8/16/01 - on site for PRE-CON w/ D. BRACKETT. Also to check placement of stakes/setbacks. DUE to very tight setbacks, DAVID TITCOMB will provide a letter. Initial plans called for a 30x34 STRUCTURE. This has been changed to 23x30 (duplex). OK to proceed given subject to a call to Titcomb.

LOCATION 79 Maggie Ln lot 13

CBL 341 A023001

FOUNDATION / FRAMING PLAN
SCALE: 1/4" = 1' - 0"

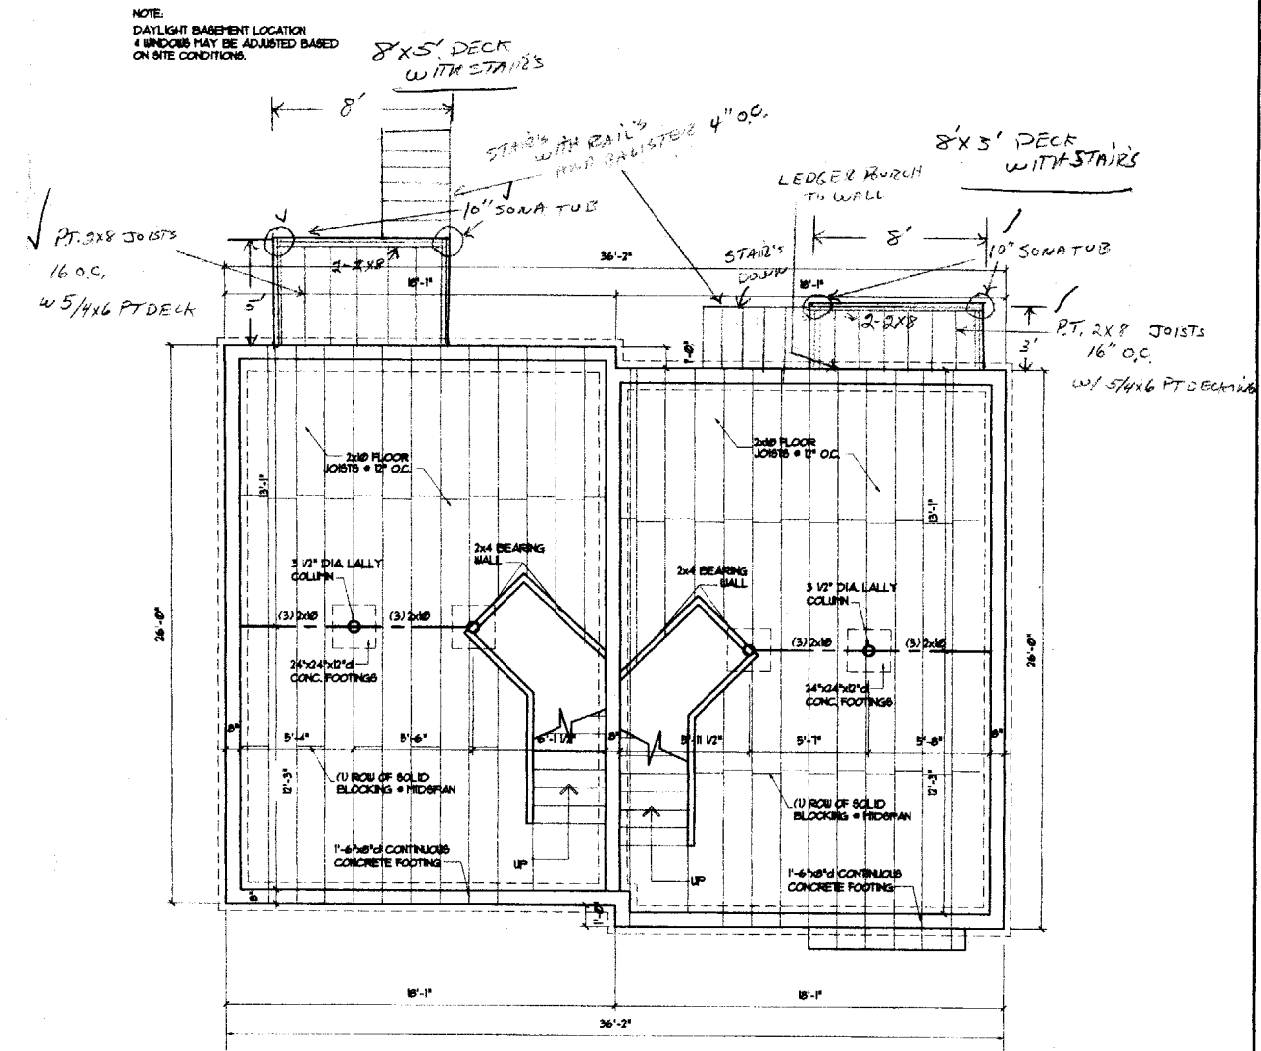
10/5/01 Framing @ cellar stairs 9" tread, must be corrected to 10" Plumb OK. Elect. wires laid on top of strapping. Must meet 1/4" rule. M

DRAWINGS THIS SHEET
ELEVATIONS / SECTION

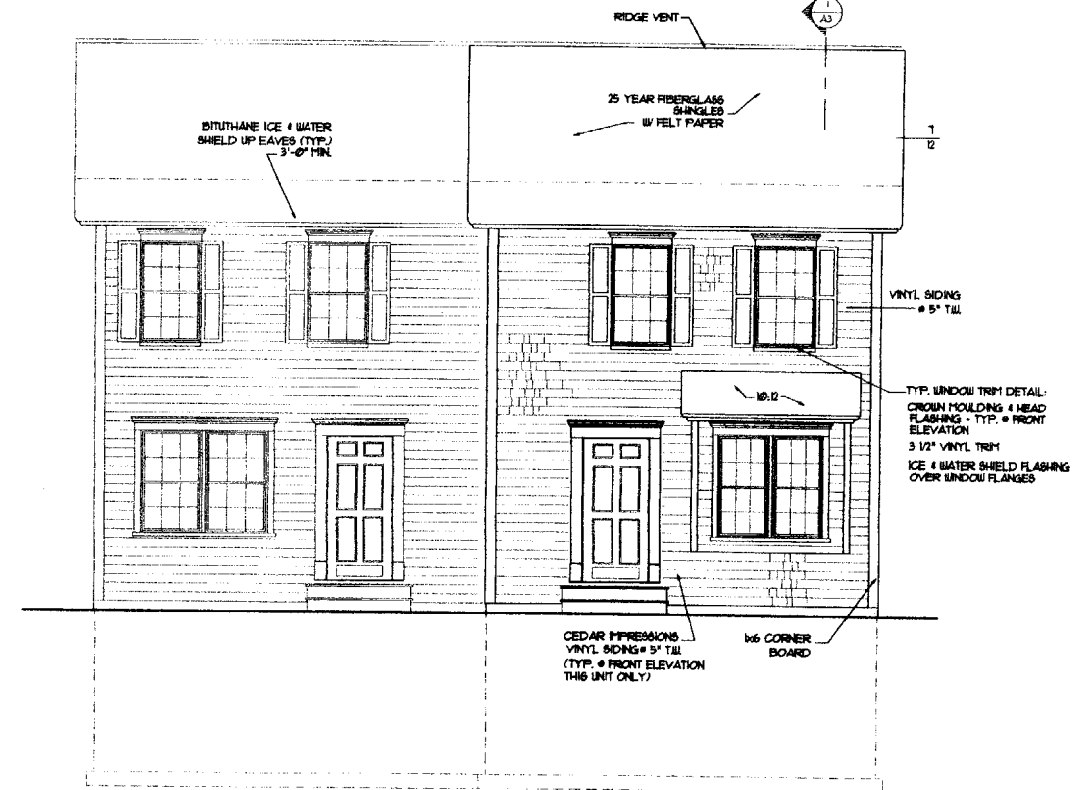
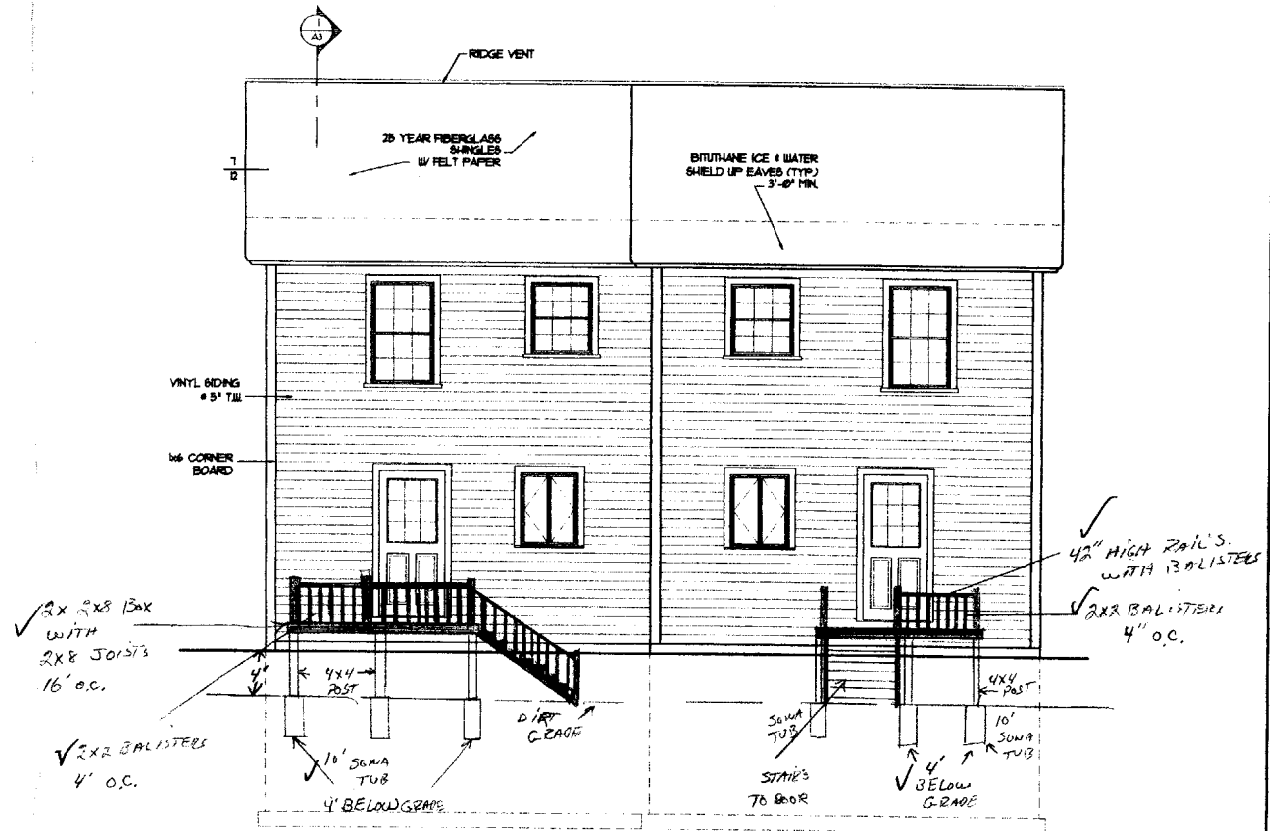
1/24/02 Treads / Elec correction - plumb / Elec find ok Titcomb will fax foundation setbacks verification per ~~#79~~ need Revised plans showing Rear Deck & Stairs Riser / Rear Deck # 179 spread 3/8 amplitude over rear will have to be adjusted - Handrails too High @ 41" # 79 all Handrails must be made continuous P
